Request R-06699

Query Type: Credit Interpretation Request

Project Details: GS-2742DA The Ribbon

Date Submitted: Wed, 29 Mar 2017

1 GROUND FLOOR PLAN - LOCATION OF CLASS B BICYCLE PARKING AND END-OF-TRIP
1:250

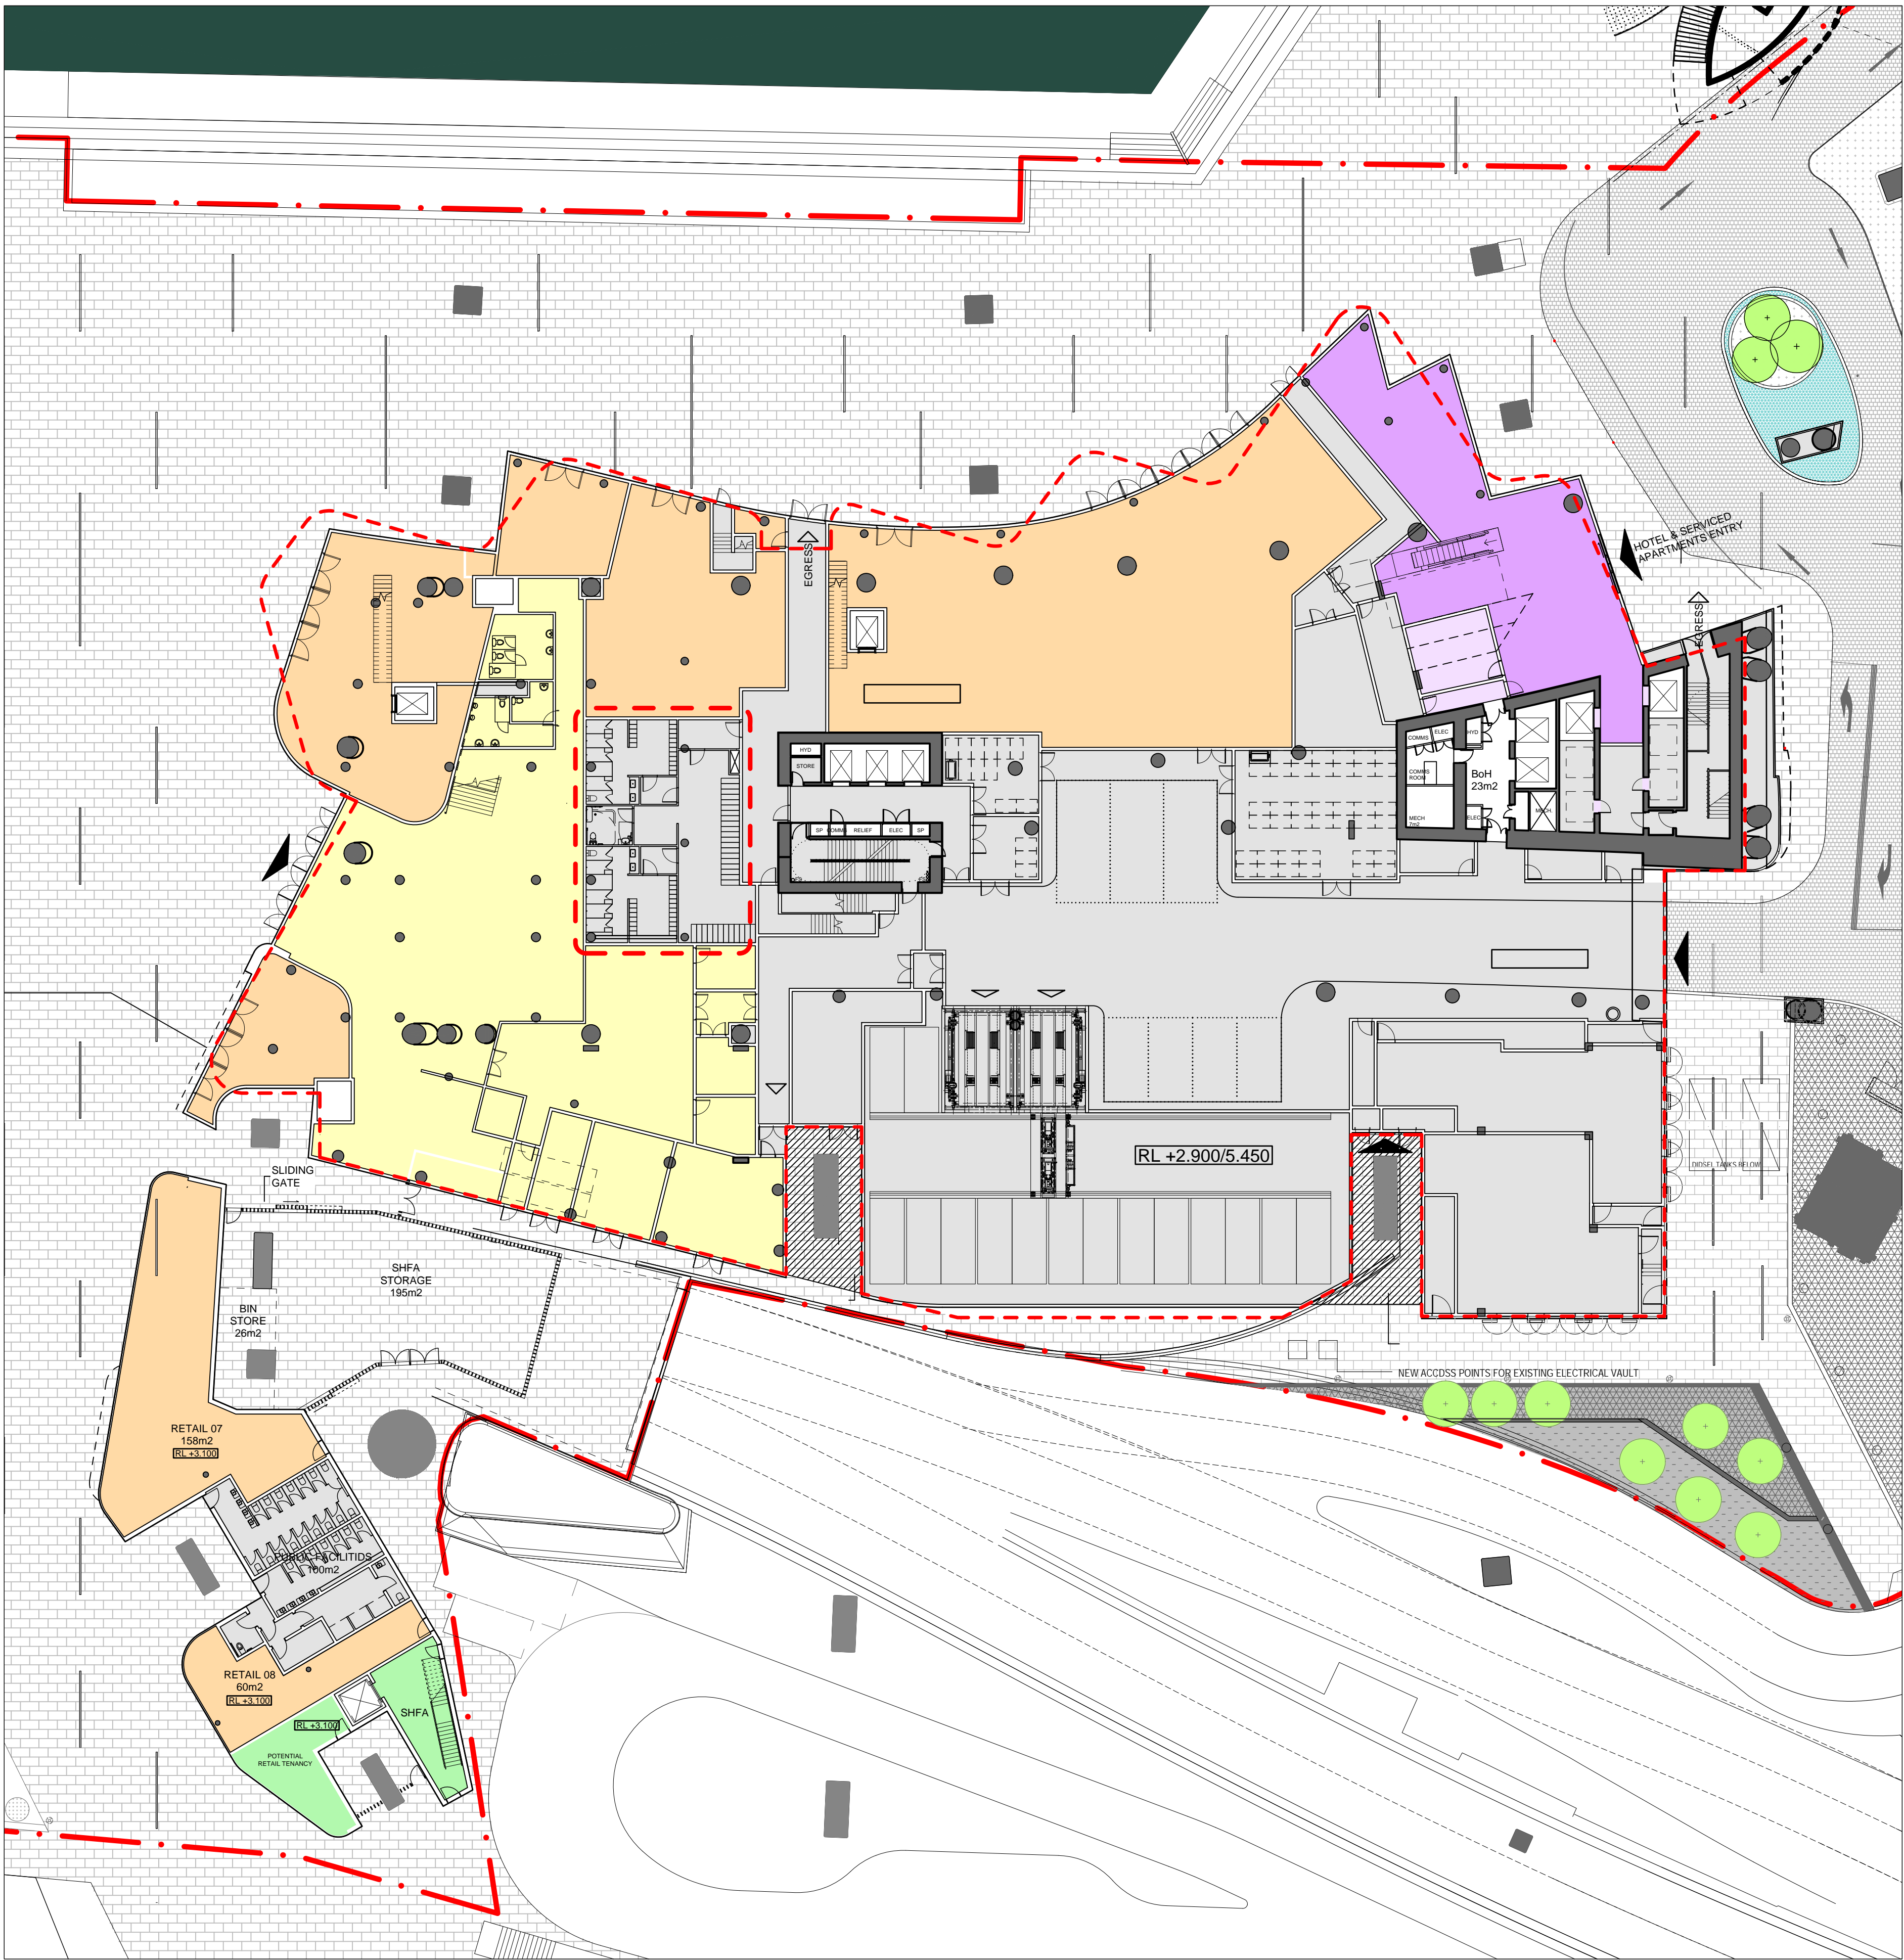
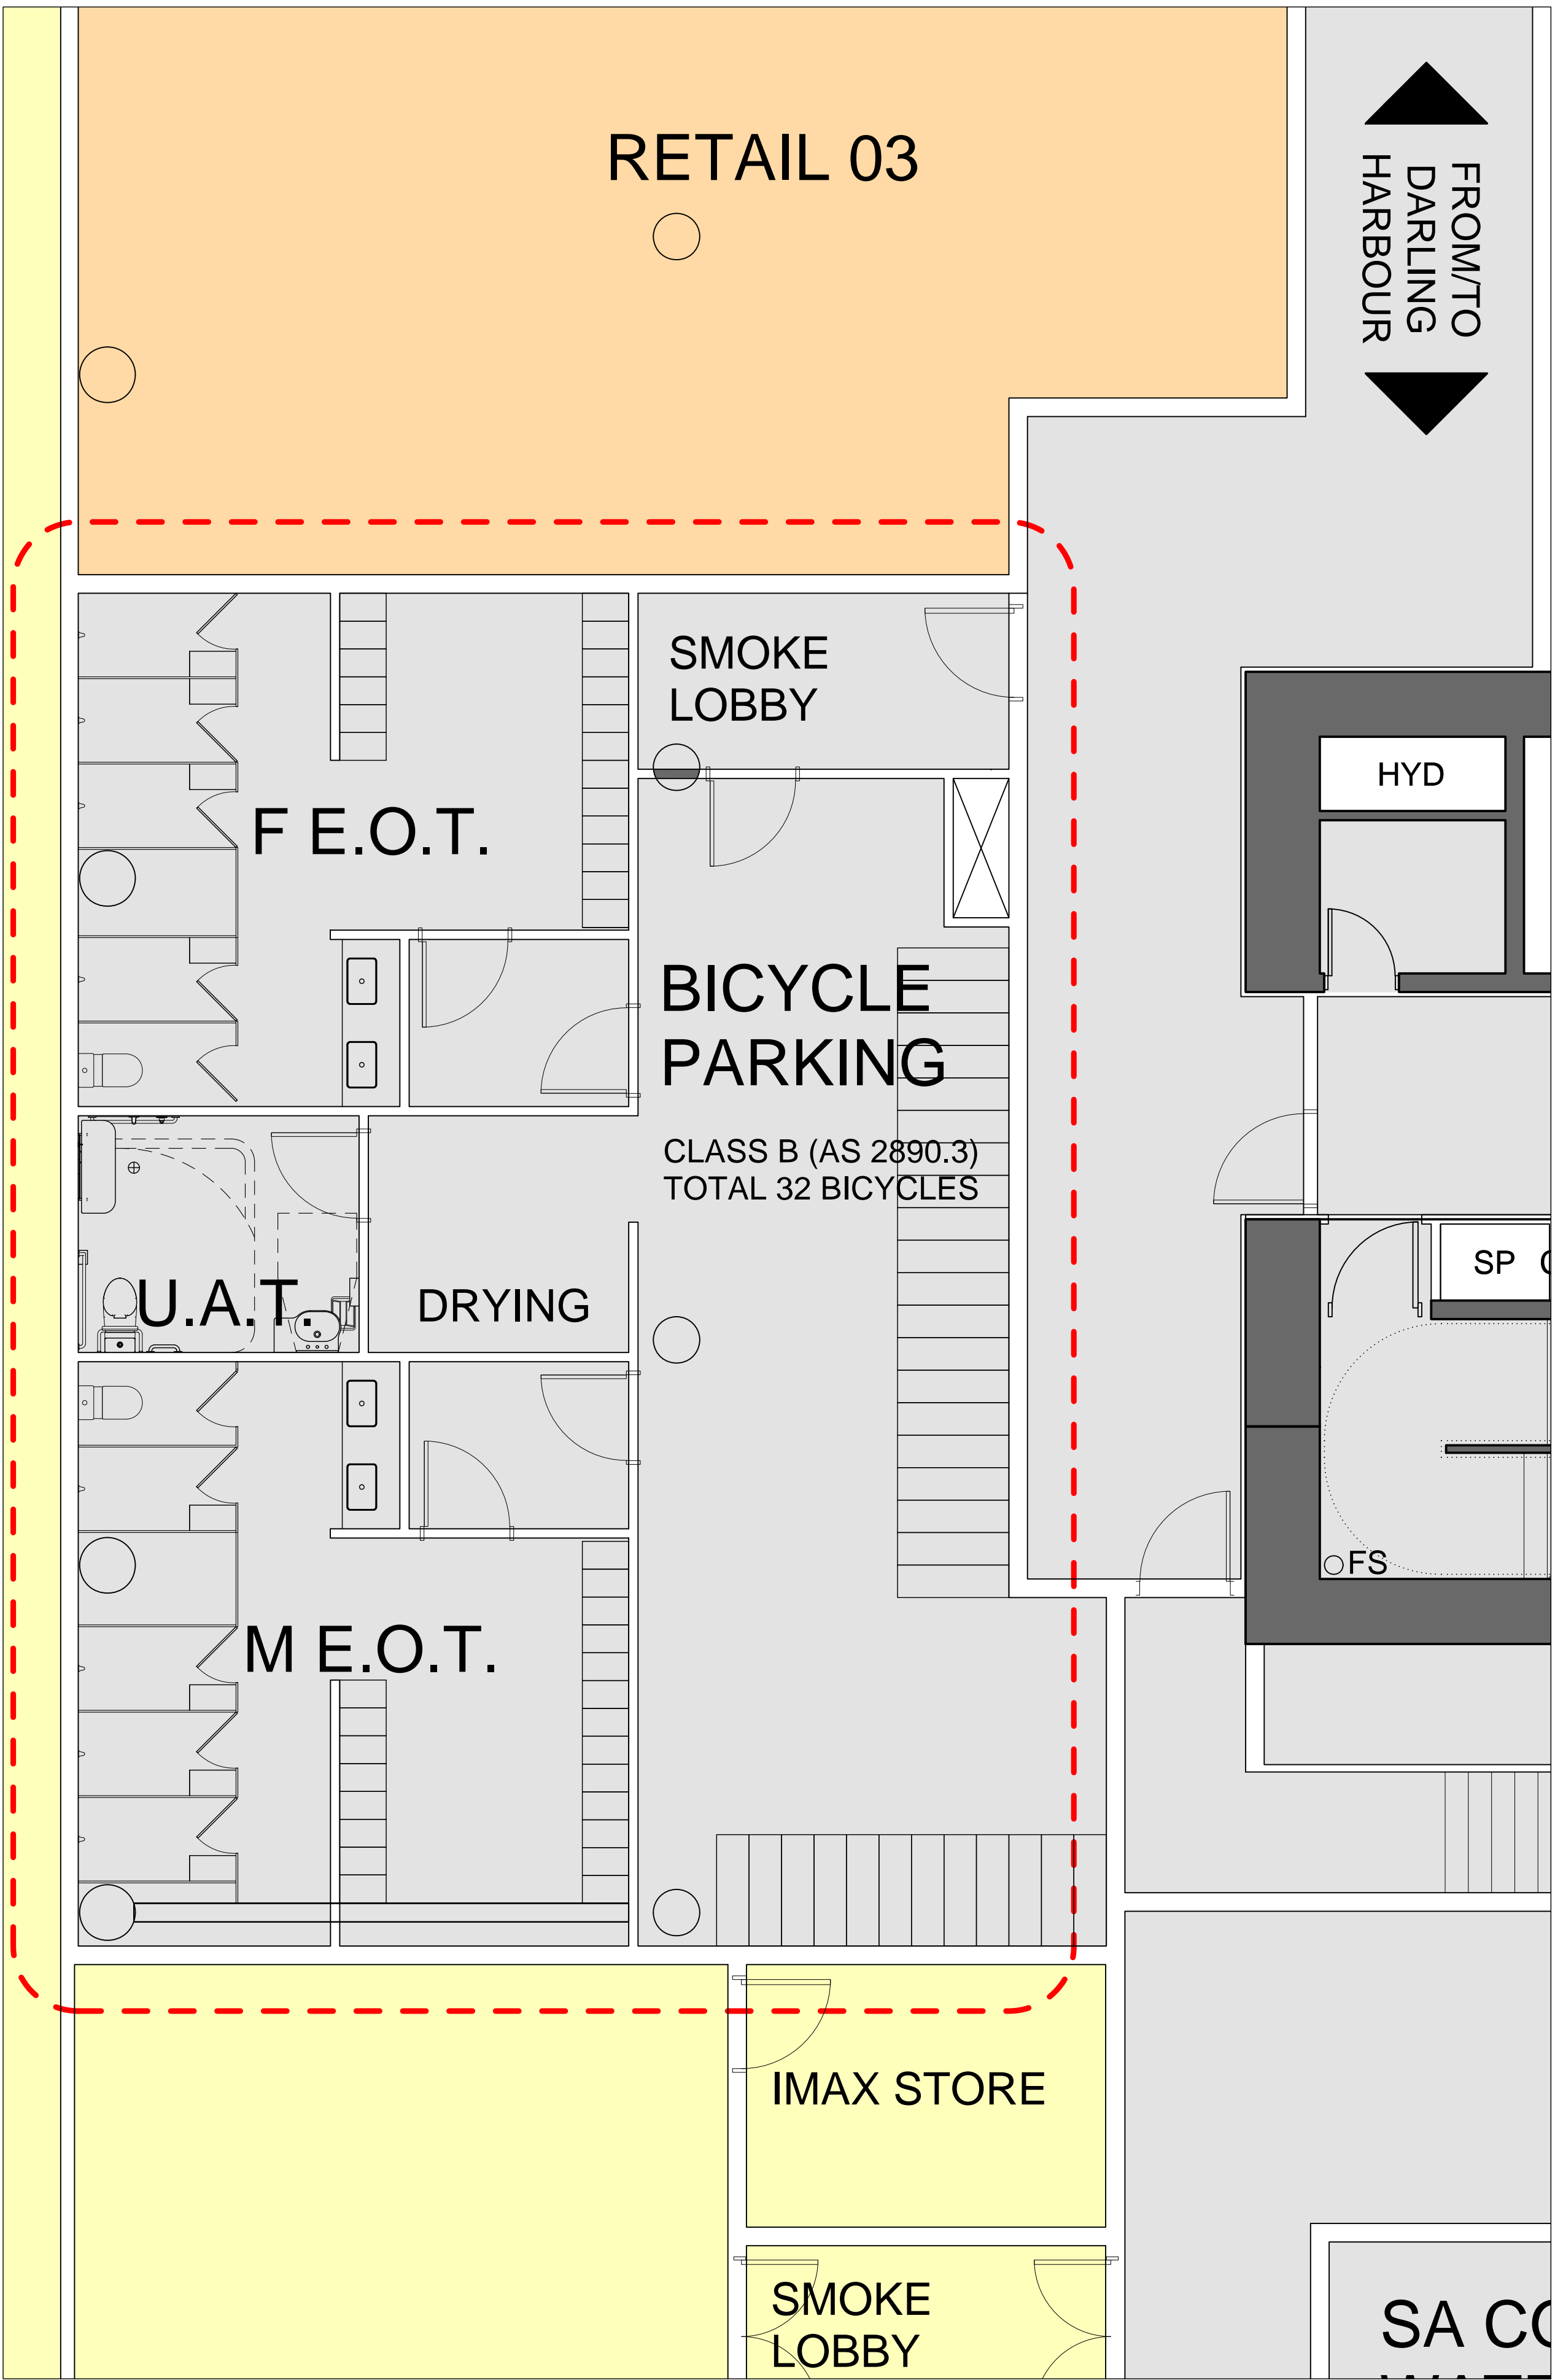
Facilities can be provided within the building's boundary, or outside. If the facilities are outside the site boundary, they must be under the control of the building owner.

Therefore, the GBCA confirms that the project team's approach conforms with the guidelines for this credit. The project team is reminded that they will be required to demonstrate these facilities will be specifically serving the project, or if shared, that appropriate apportioning is implemented.
